Re: A417 Missing Link at the Air Balloon

National Highways Application for a Development Consent Order

Climate Emergency and relevance to Walking and the Countryside

Review of Route Options based on NZS for the A417 Missing Link at the Air Balloon

Figure 21: Indicative domestic transport emissions pathway to 2037

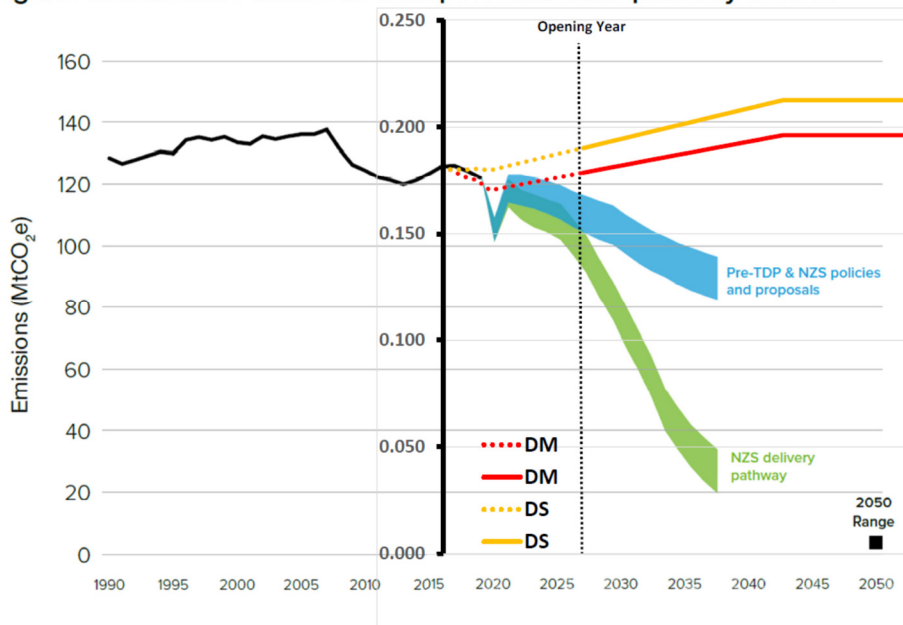
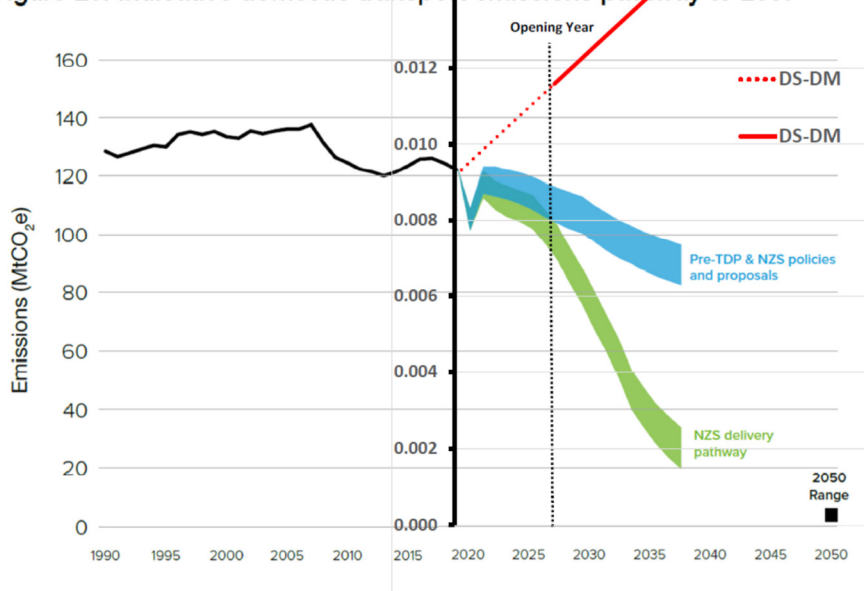
The document suggests, with a supporting graph on page 24 of 27, that the proposed scheme is unlikely to meet Government Net Zero Strategy (NZS) - a legally binding policy under section 13 of the Climate Change Act 2008 (CCA).
